Consultation Response from KC, Lead Local Flood Authority
2023/93704 land northwest of, Urban Terrace, Denby Lane, Grange Moor, Huddersfield, WF4 4EB
Erection of 10 dwellings and associated works
Date Responded: 18th August 2024 Responding Officer: Paul Farndale Responding Ref:

Further to our comments dated 26th February 2024, Kirklees Flood Management & Drainage OBJECTS to this application.

1 Proposed Site Layout

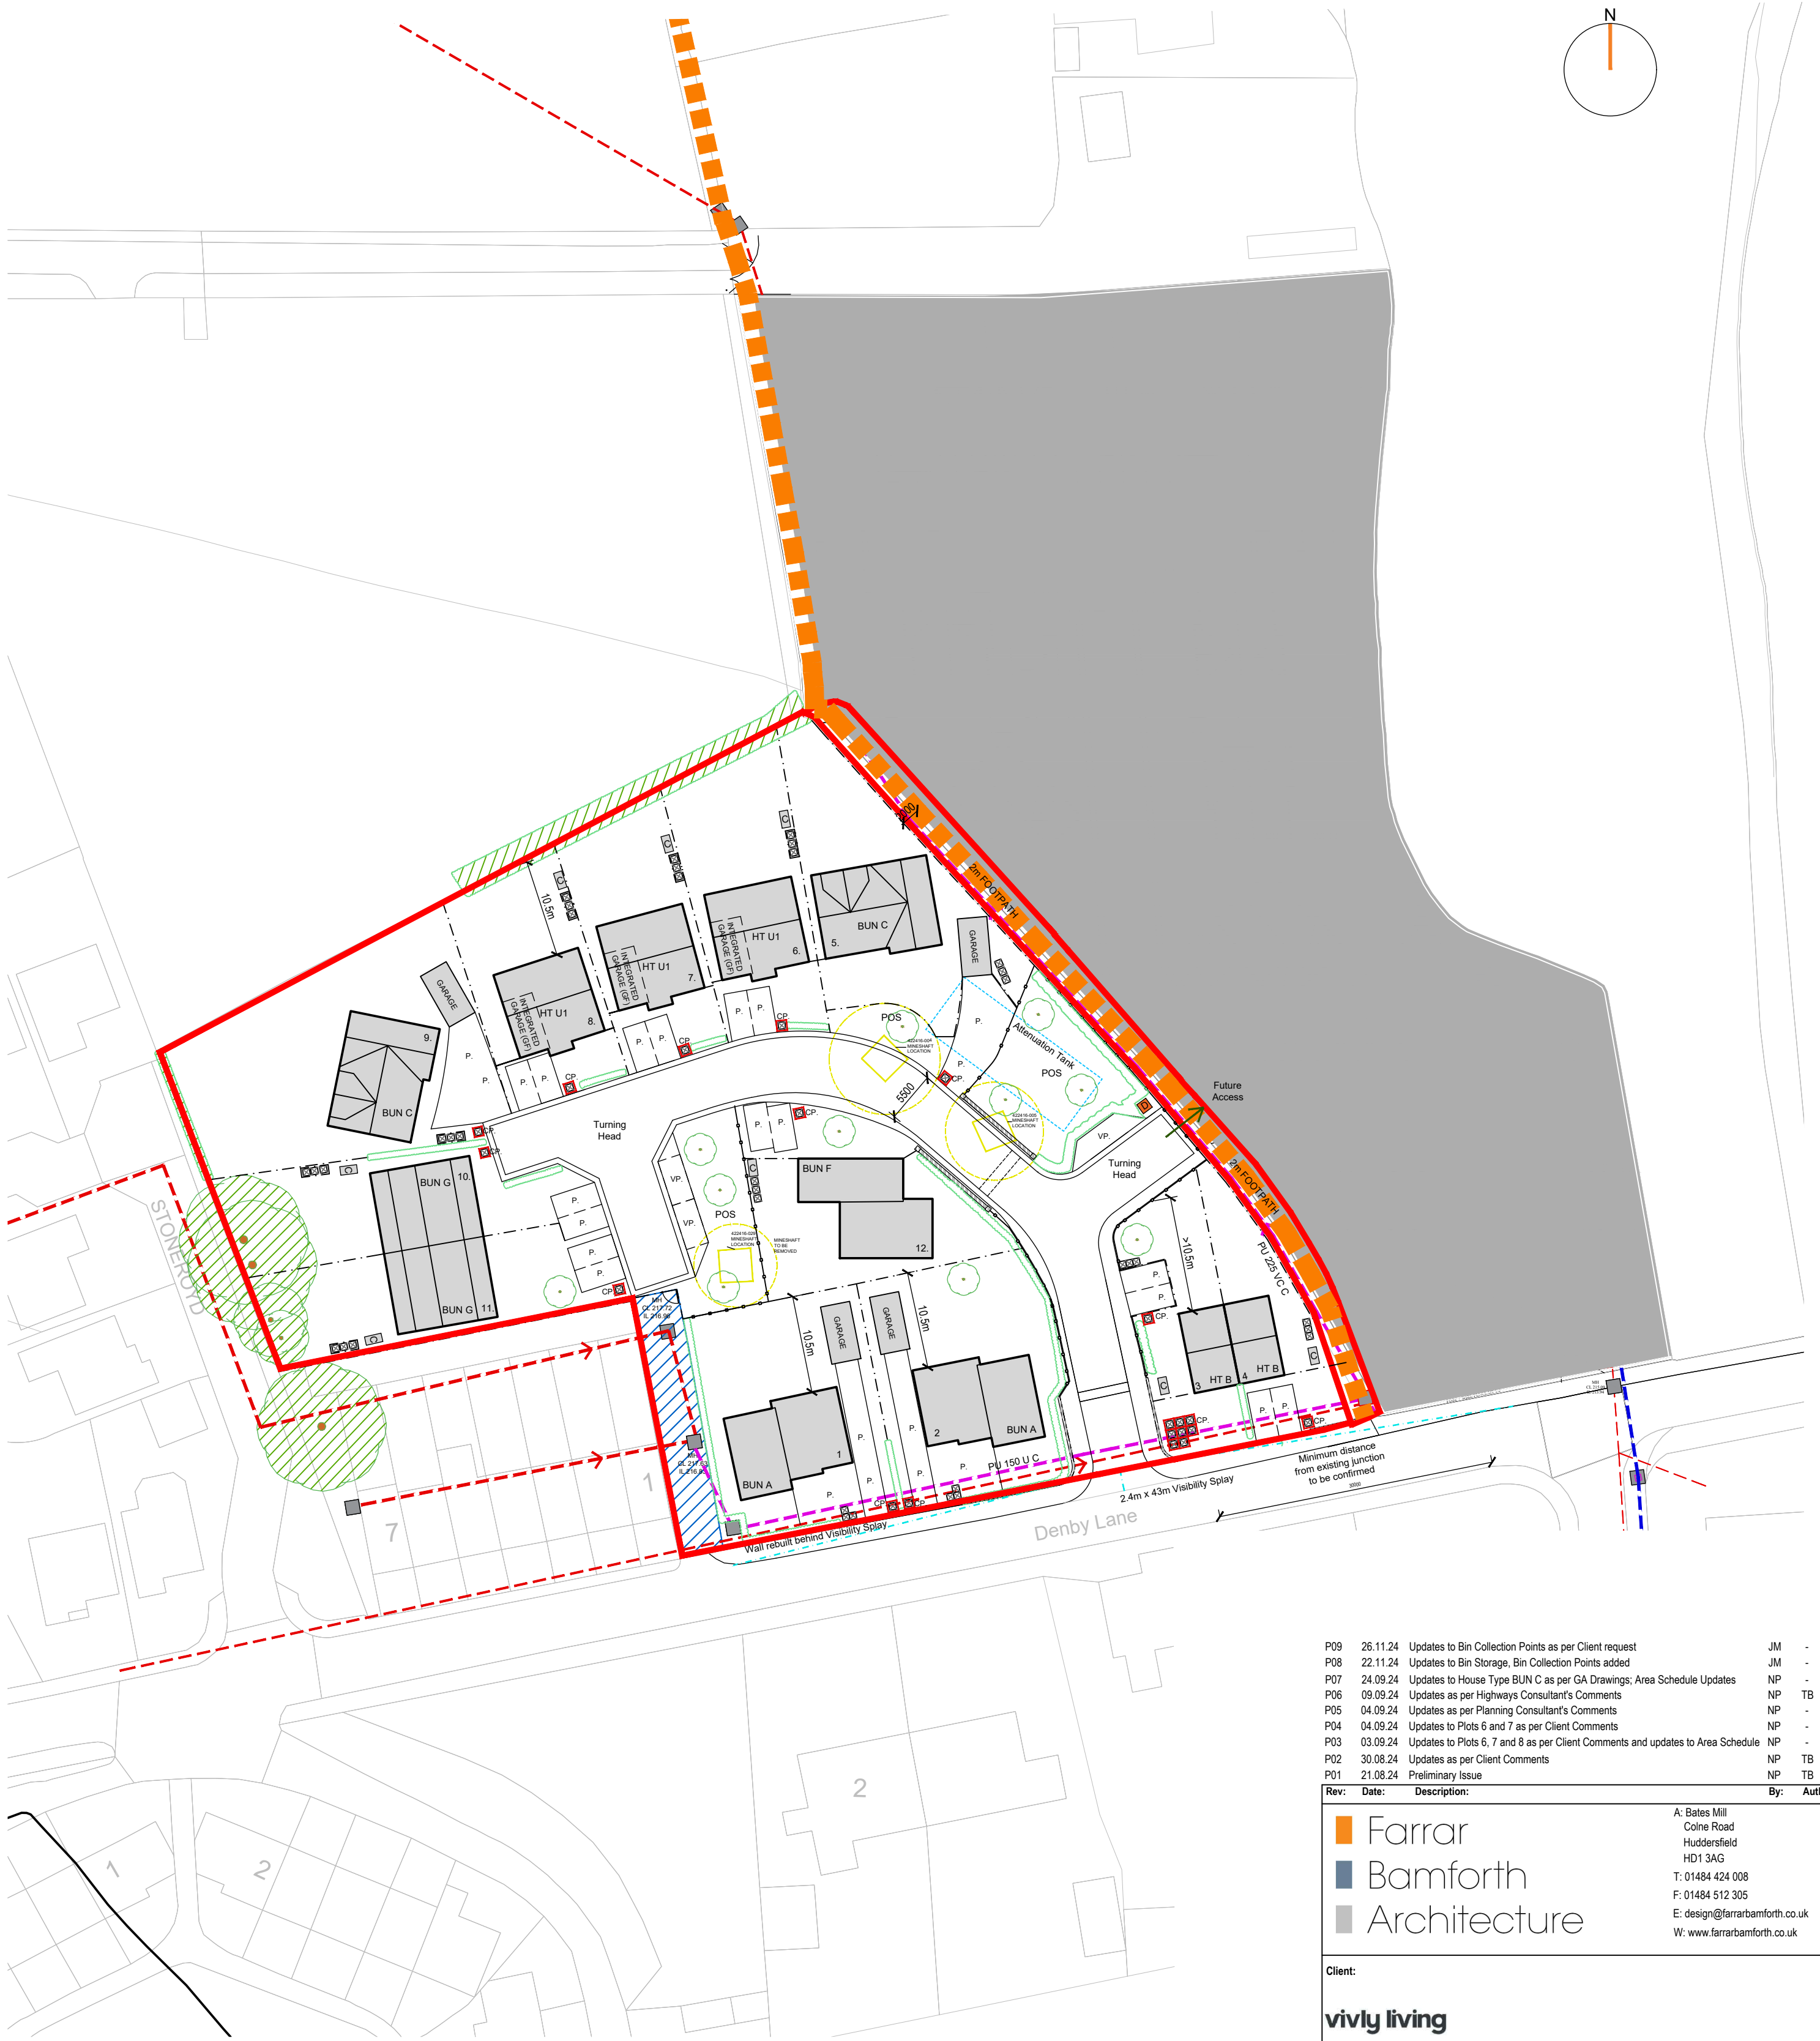
Information has come to light from shared data with Flood Risk Management Authorities that surface water from the fronts of properties 1-7 Urban Terrace drain to a shared soakaway in the development site. Plans show this conflicting with plot 1.

A 5 metre stand off is required for buildings adjacent to a soakaway.

BGS data suggests the part of the development site has serious constraints for soakaways, so it is not envisaged that this means of disposal of surface water will work across the site.

Our comments on crate storage still stand regardless of the management company maintenance plan submitted.
